Response to Comments: 23 Ocean Avenue Development

Date: September 8, 2016

Comments Submitted by: Lauren Swett, PE of Woodard & Curran on 2016-07-14

**SECTION B-B' - RAIN GARDEN AND DRIVEWAY PERVIOUS PAVERS**  
NOT TO SCALE

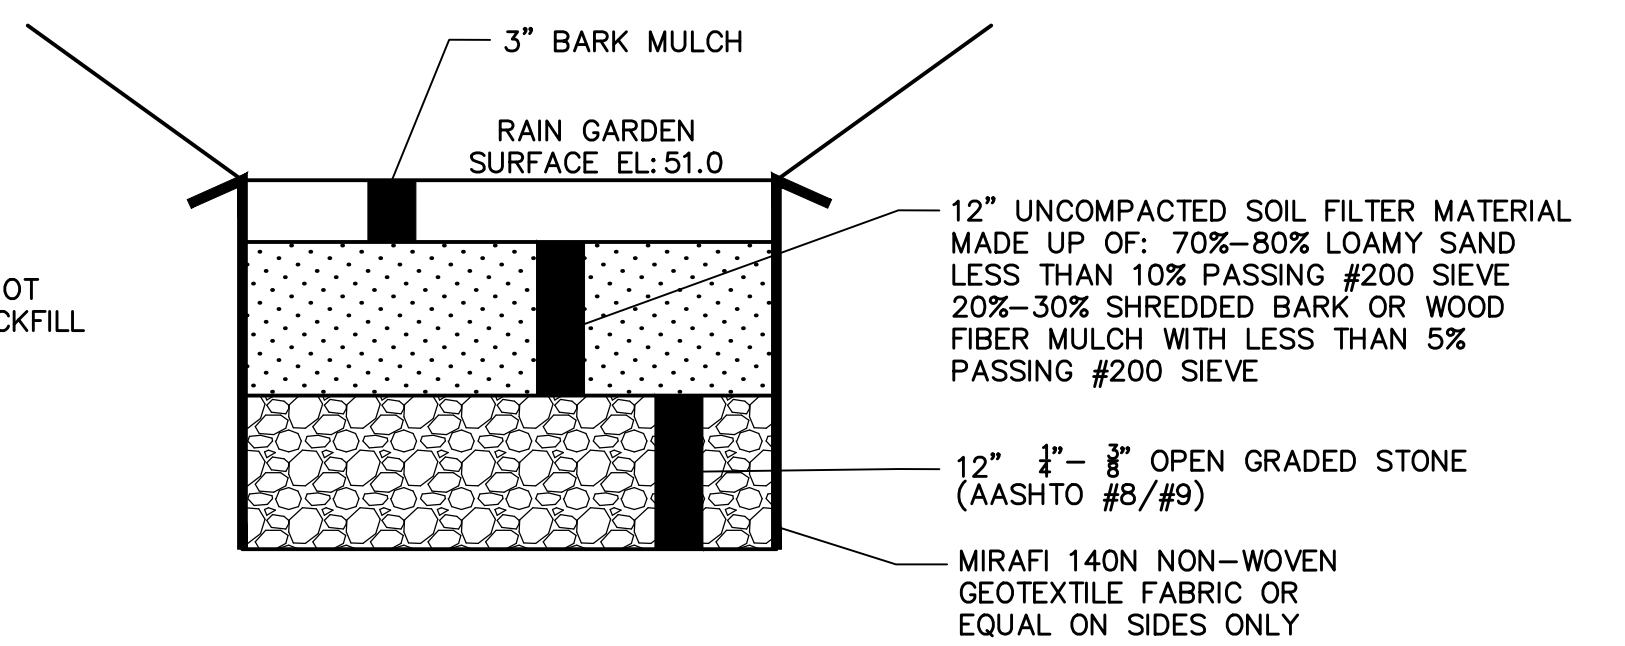
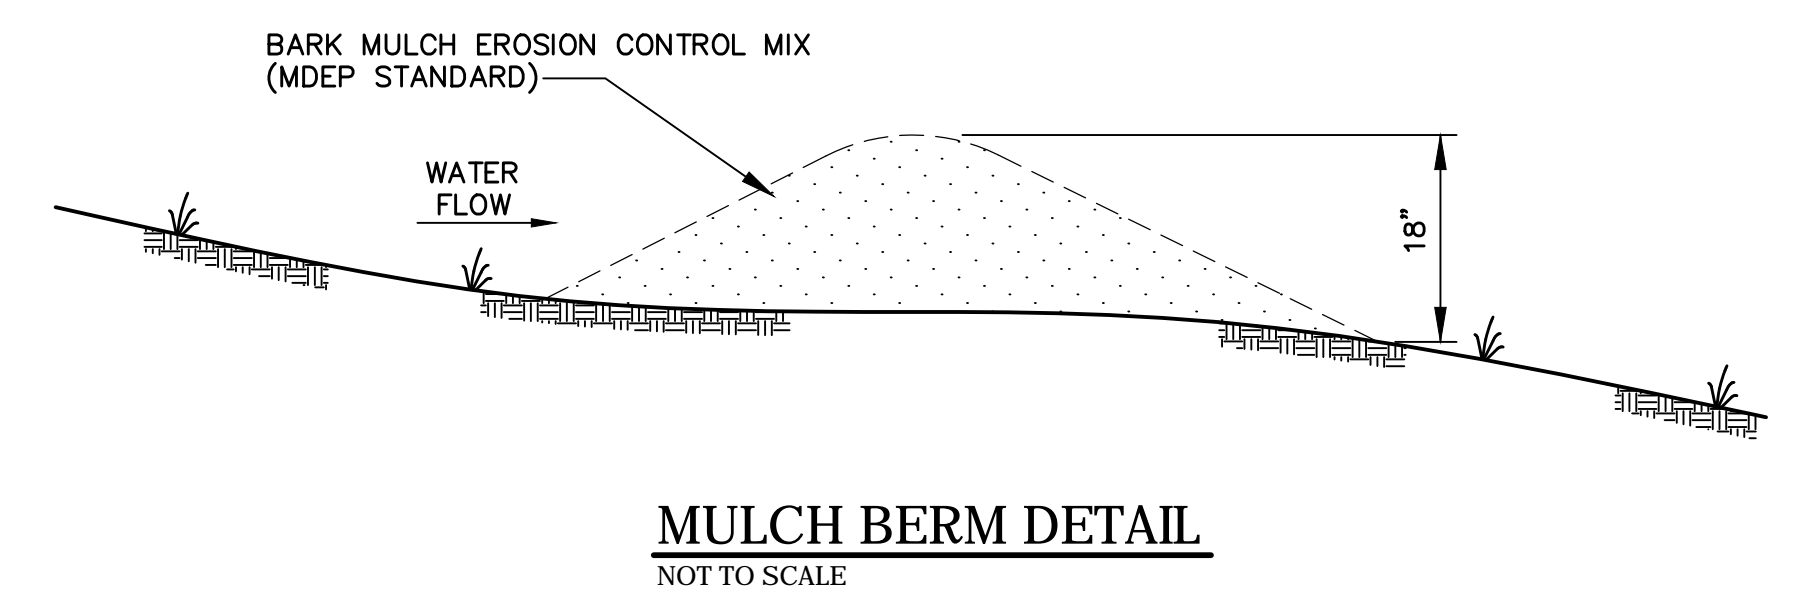
The proposed rain gardens do not appear to have any overflow structures or bypass outlets.

The rain garden in the southeastern corner of the site will overflow through the driveway apron to the Hersey Street gutter. This has been clarified on the plans and additional information on grading has been provided so that it is clear that overflows should through the driveway apron and not onto the sidewalk/esplanade.

Due to changes in the parking area and because the roof of the new building will now drain to Ocean Avenue (to be connected to a future separated stormdrain) the northern rain garden (near the existing building) has been eliminated.

UNDERGROUND ELECTRIC/COMMUNICATIONS UTILITY TRENCH DETAIL
NOT TO SCALE

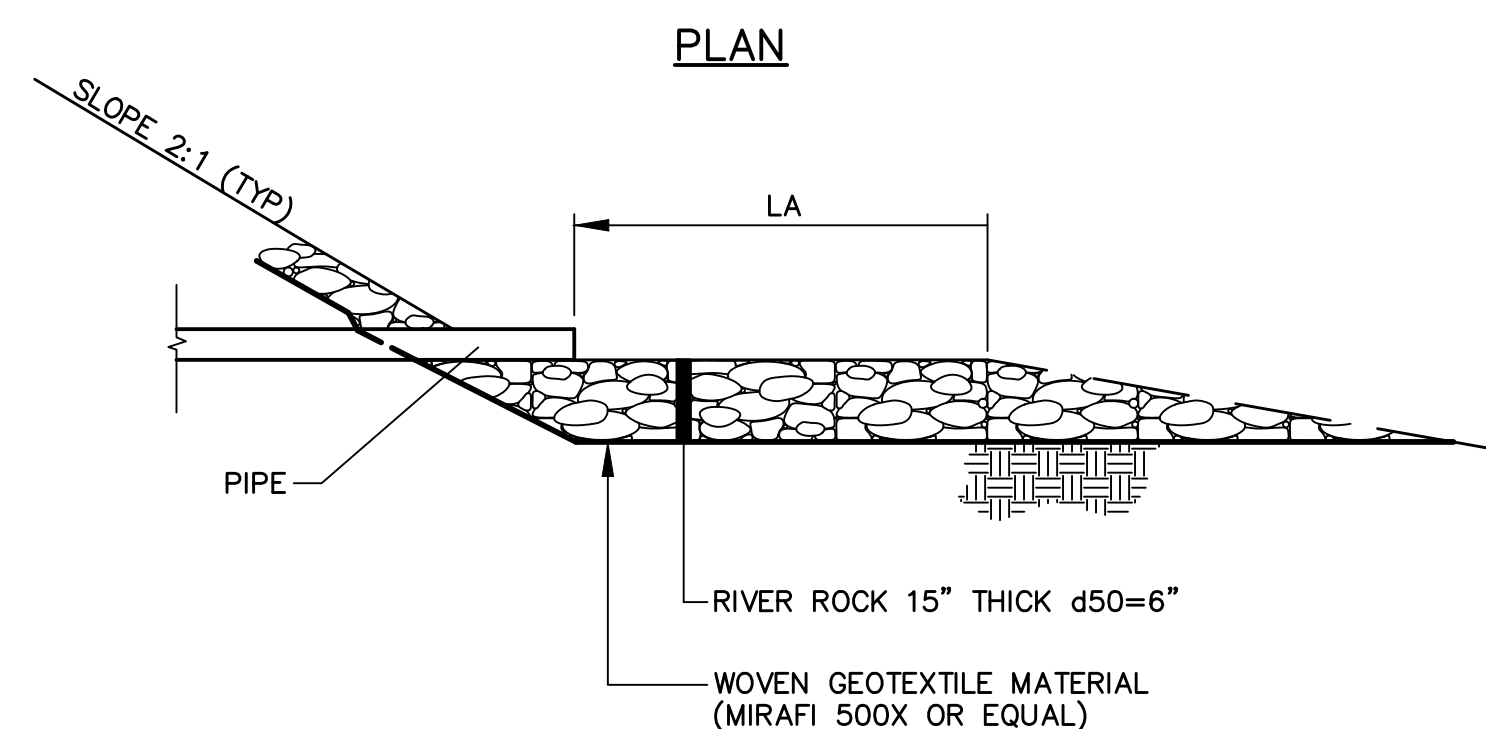
2. The Applicant has indicated on their plans that they will be extending gas and electrical services from meters to be installed on the existing building to remain. The Applicant should provide verification from both Unitil and CMP that the ability to serve exists, and that the configuration will be acceptable to each utility.

As requested by the City, electrical and communications utilities have been

reconfigured to run from an existing pole (Pole #1, Nynex 1) on the opposite corner of Hersey- Ocean, beneath Hersey Street to the new building, in a more traditional alignment. The applicant has set up an account with CMP for the new building and is in the process of scheduling an onsite meeting. The applicant is not proposing to install a new gas service to the new building.

STORWATER FILTER DETAIL
NOT TO SCALE

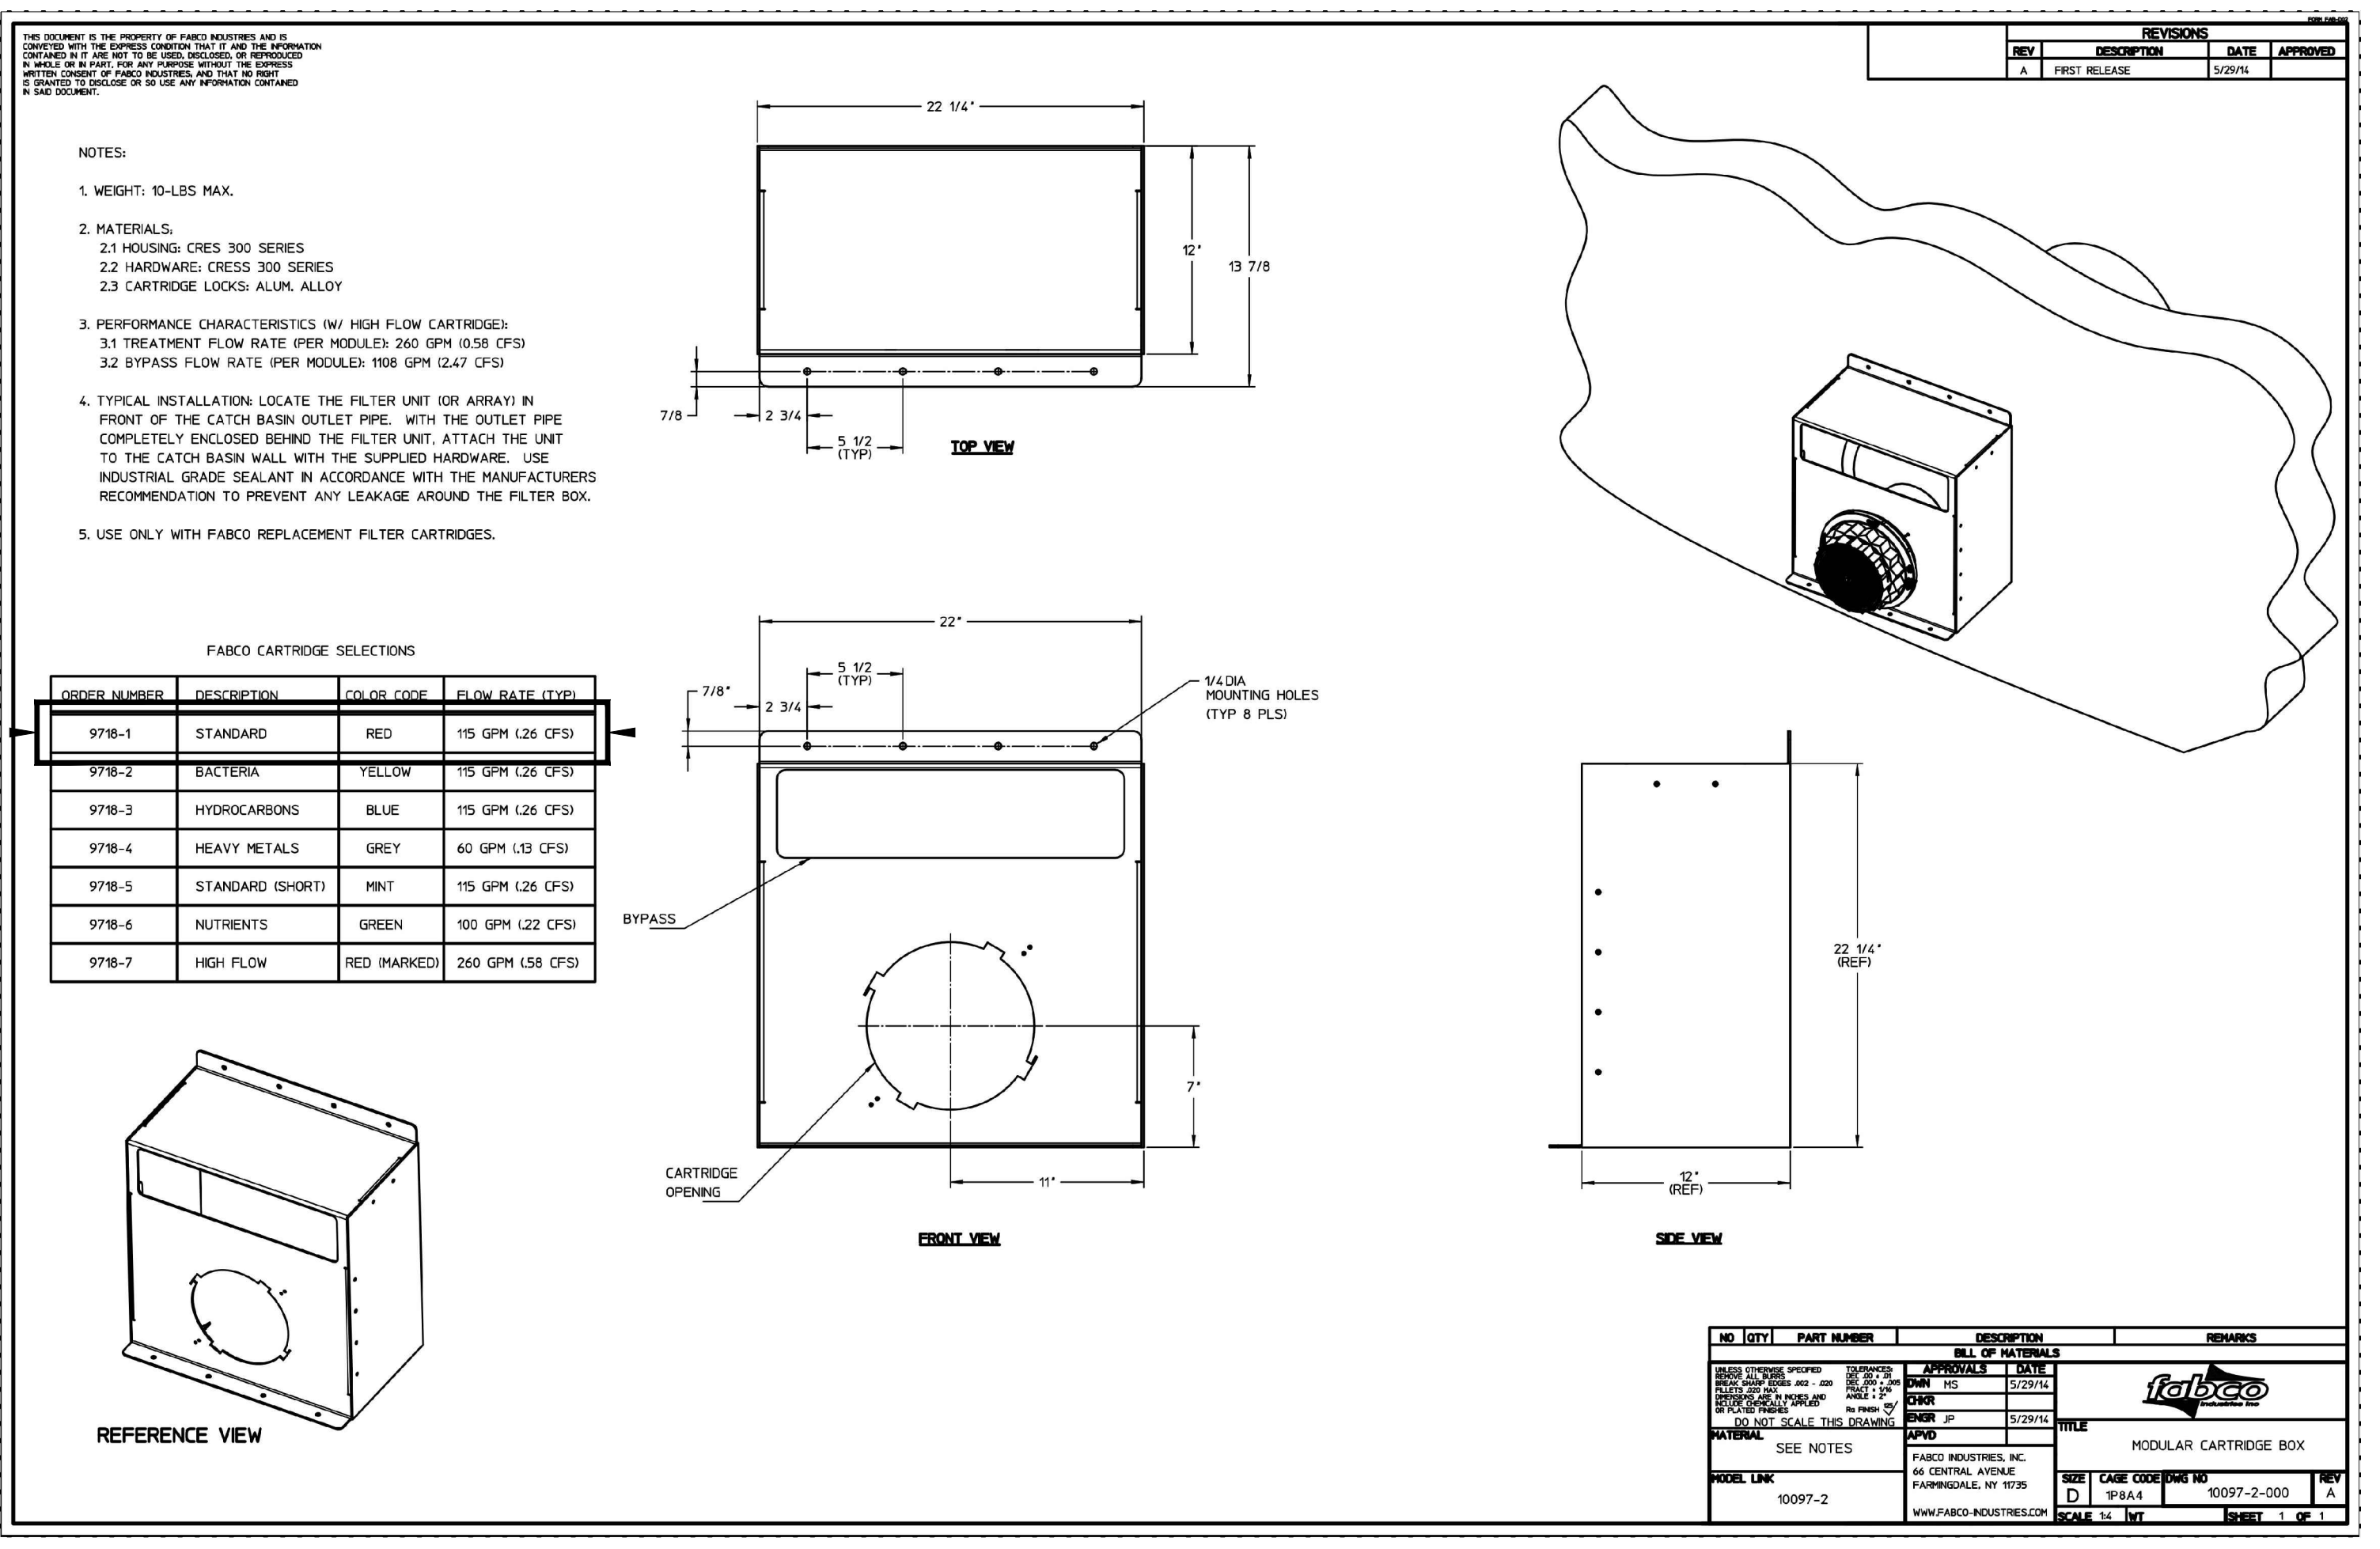
- b. General Standard: The project is required to include stormwater management features for stormwater quality control. The Applicant is proposing to install rain gardens, pervious pavers, and underdrained roof drain collection systems on the site. The proposed systems are anticipated to provide acceptable stormwater treatment, but the Applicant is required to provide calculations and additional design information verifying compliance with the Maine DEP Chapter 500 and City of Portland Technical Standards Section 5.

Runoff from the proposed building's roof (2,824 SF) will drain through a roof drain cartridge filter before discharging to an existing catch basin Ocean Avenue. See attached sizing information and specifications from the manufacturer and manufacturer's representative.
